**Application Reference:** 2025/0082

**Site Address:** 36 Manor Fields, Great Houghton, Barnsley, S72 0BF

This application seeks full planning permission for a 2 storey side extension, and new hardstanding to front to create additional parking space, to 2 storey semi-detached dwelling

Drawing Title **PROPOSED PLANS**

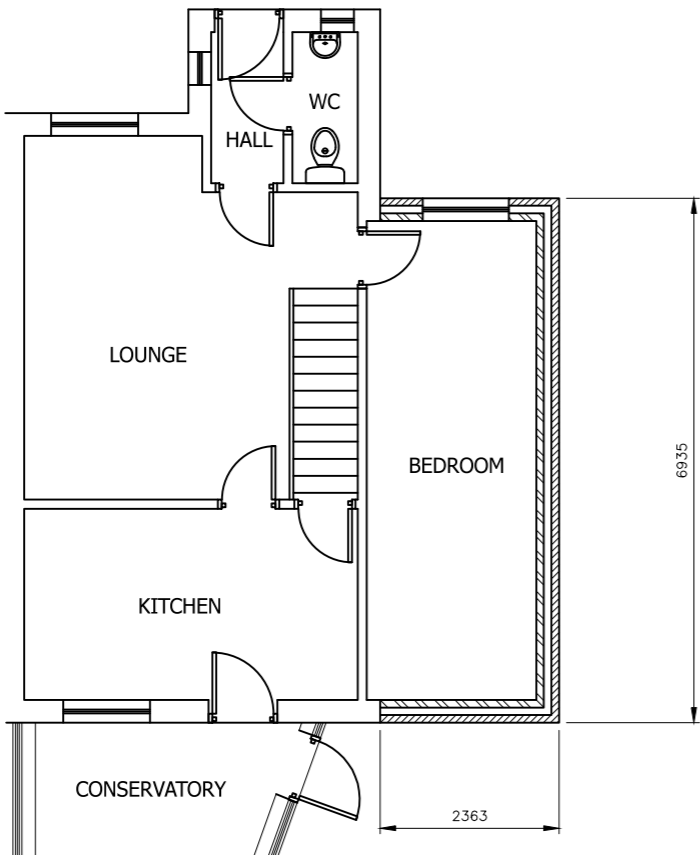
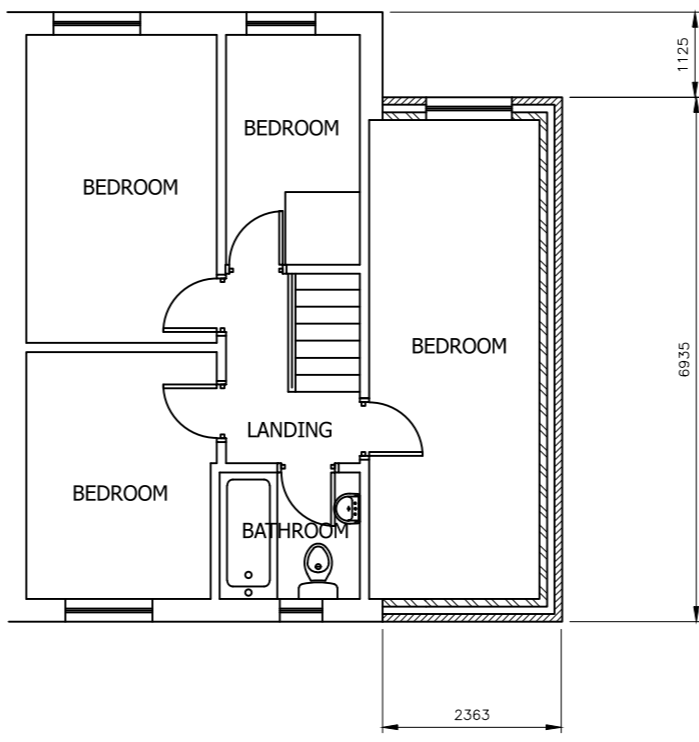
The scale is of an acceptable size and is compliant with the local SPD House Extensions and Other Domestic Extension which require a side extension on a dwelling not to exceed two thirds of the width of the existing dwelling. Equally complaint is the set back of the extension from the front elevation of the dwelling, and a visible step down in the roof. Both these features illustrate subordination of the extension to the host dwelling. With local policy requirements met, it would be considered that the scale of the proposal would have a limited impact.

Drawing Title **SITE PLANS**

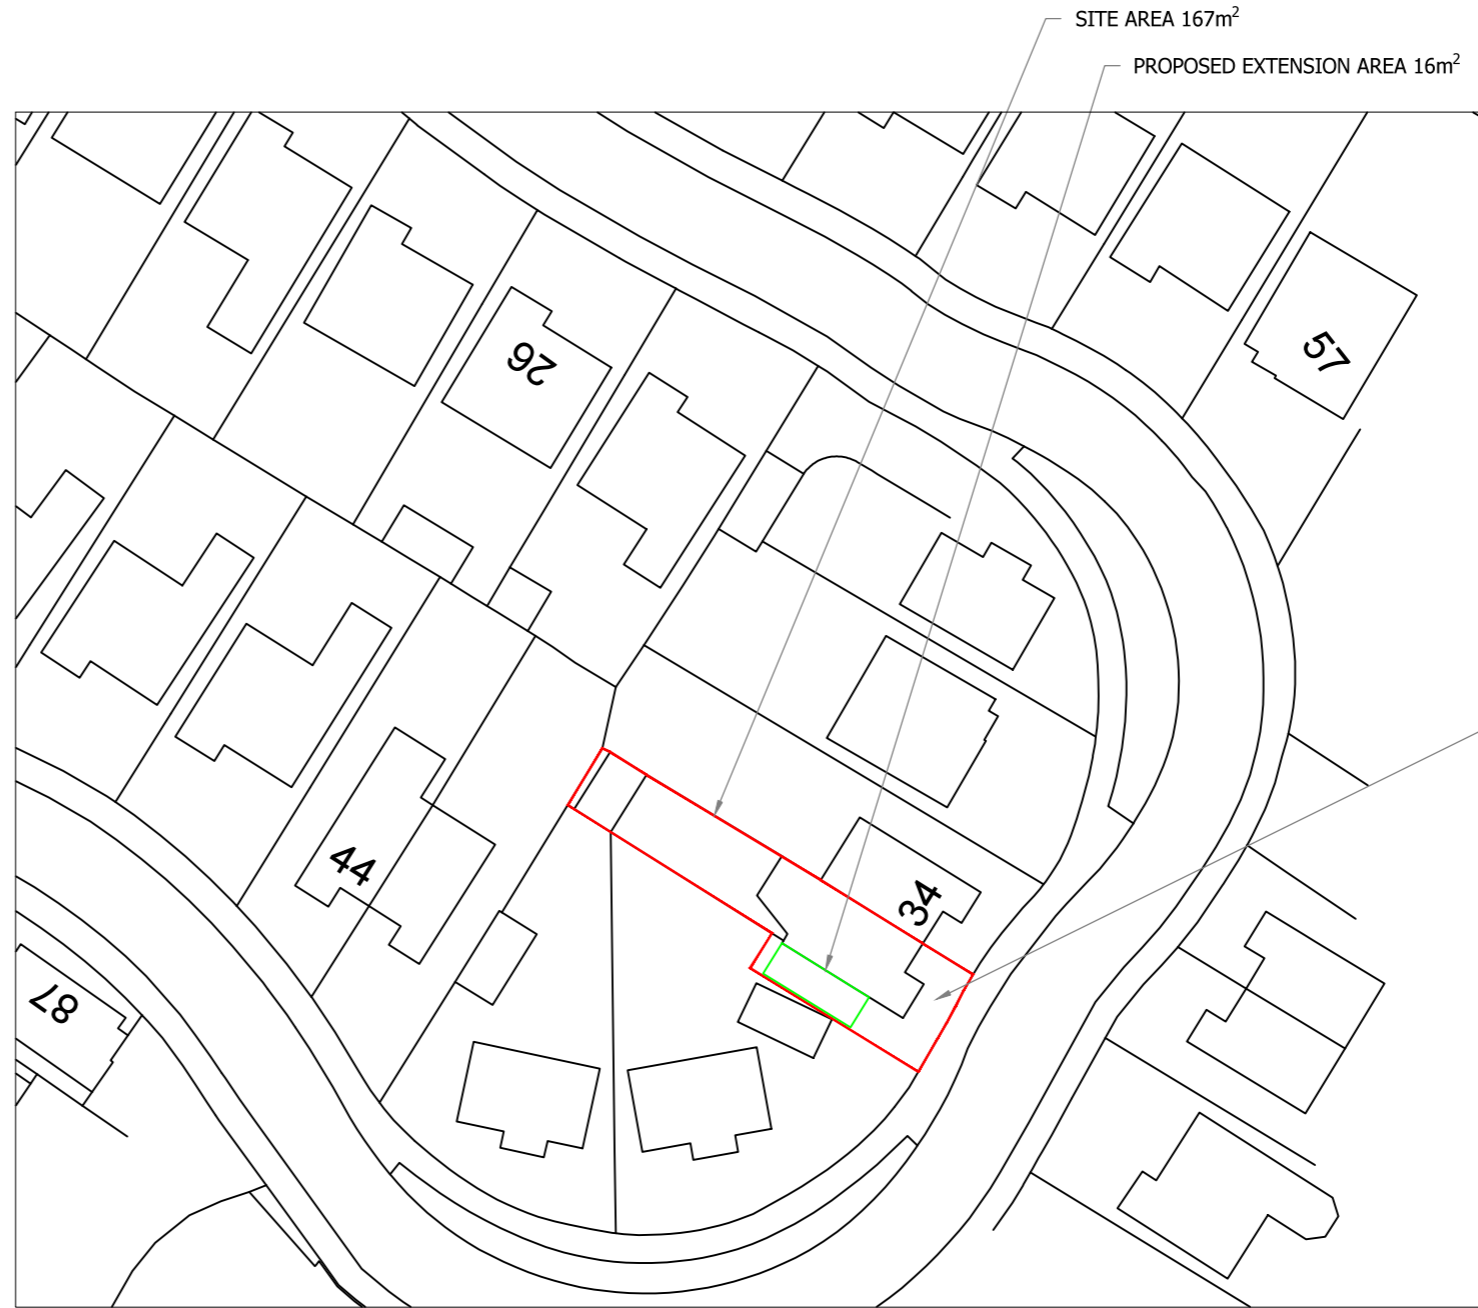
With the current enclosed front garden required to be re-surfaced for compensatory parking provision, whilst there may be an impact on the loss of garden space, amenity space remains in the rear garden and the impact on the character of the dwelling or broader street scene would only be considered as having a limited impact.

Highways DC initially objected to the proposal on the grounds of insufficient parking provision and potential difficulty in accessing the proposed additional parking provision. On further review of the application, whilst sufficient parking provision at local policy standards, namely two spaces of a minimum size of 2.5m by 5m may not be completely met, it does come very close. Additionally, despite the side extension being constructed on what may have been original parking provision, evidence indicates that a side gate has restricted parking provision at the address for at least fourteen years, effectively rendering the dwelling with one parking space. On balance, with the proposal still providing an increase in available parking provision,

and with a condition to ensure such provision is constructed to the standards generally required by Highways DC, whilst the highways concerns has been noted, the actual impact would be considered as modest and not sufficient enough to merit refusal of the application.

PROPOSED ELEVATIONS

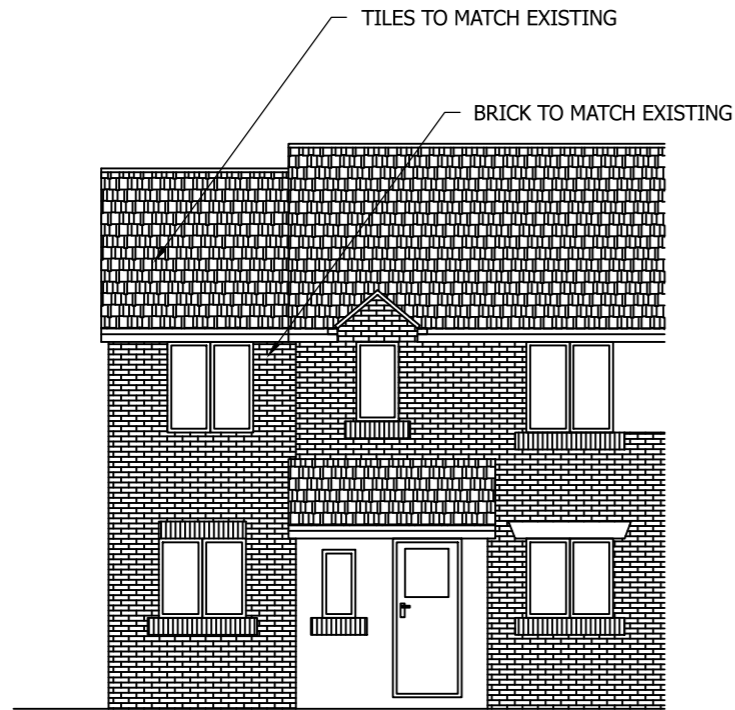
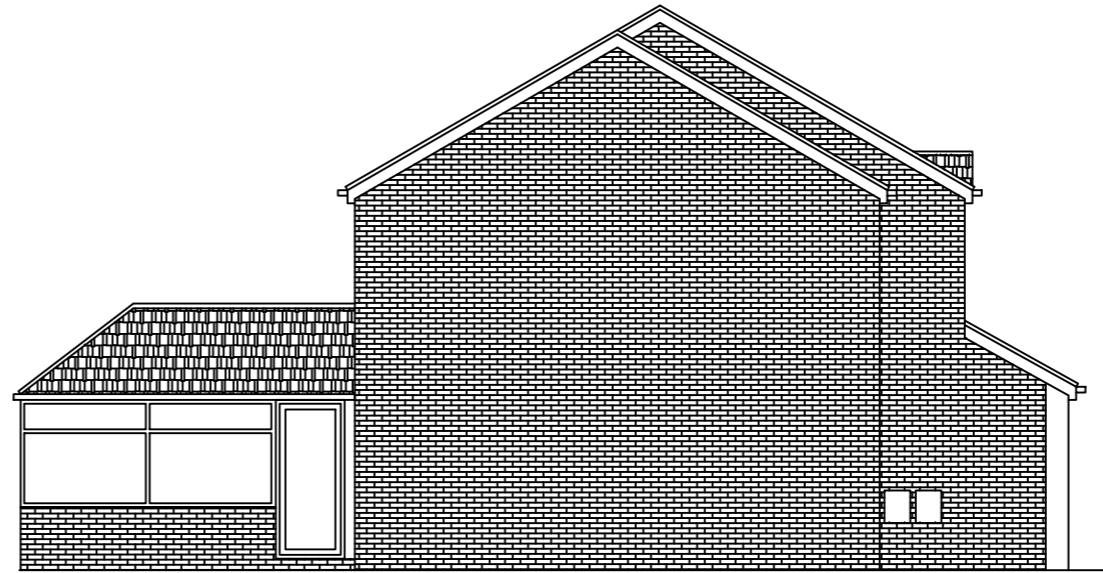
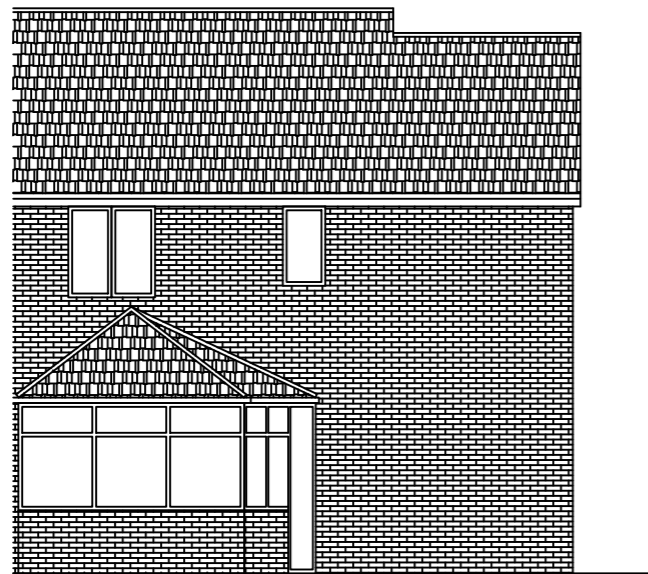
The design of the front elevation is fairly consistent with the design of the existing dwelling, this includes similar size and style of windows but only one of the two new windows feature architectural features found around the existing windows. Understandably, the existing first-floor side elevation window is not replaced within the extension as this may have created an

issue of overlooking the neighbouring dwelling No.38 dwelling, and almost certainly their garden. For the reason of protecting the amenity of No.38, the rear elevation is completely blank, and devoid of features. Whilst the design of the rear elevation would have a negative impact on the rear character of the dwelling, the design of the side elevation would be neutral, and the principal, front elevation would be acceptable. Therefore, the overall design and subsequent impact on the character of the dwelling would be moderate.

The proposal appears to have been designed to minimize its harm on neighbouring amenity. The side window of the rear elevation has not been replicated within the extension, and although considered as a negative design feature, the omission of any windows or doors on the rear of the extension eliminates the possibility of overlooking neighbouring dwellings or gardens, especially No. 38.
